RE: Planning Application; 2023/CLASS MA/91469/; 2, 4 & 6, Thornton Lodge Road, Thornton Lodge, Huddersfield, HD1 3JQ; Prior notification for change of use from shop/restaurant to 3 dwellings.

A4 Location Plan  
1 : 1250

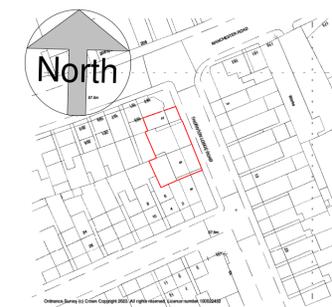
Grouped Plans and Elevations [id 990926] contains the location plan. The location plan incorrectly depicts the boundary of 6 Thornton Lodge Road rear amenity space. This is shown in the figure below along with the corrected boundary representation:

We request that the above issue is investigated/corrected as appropriate please.
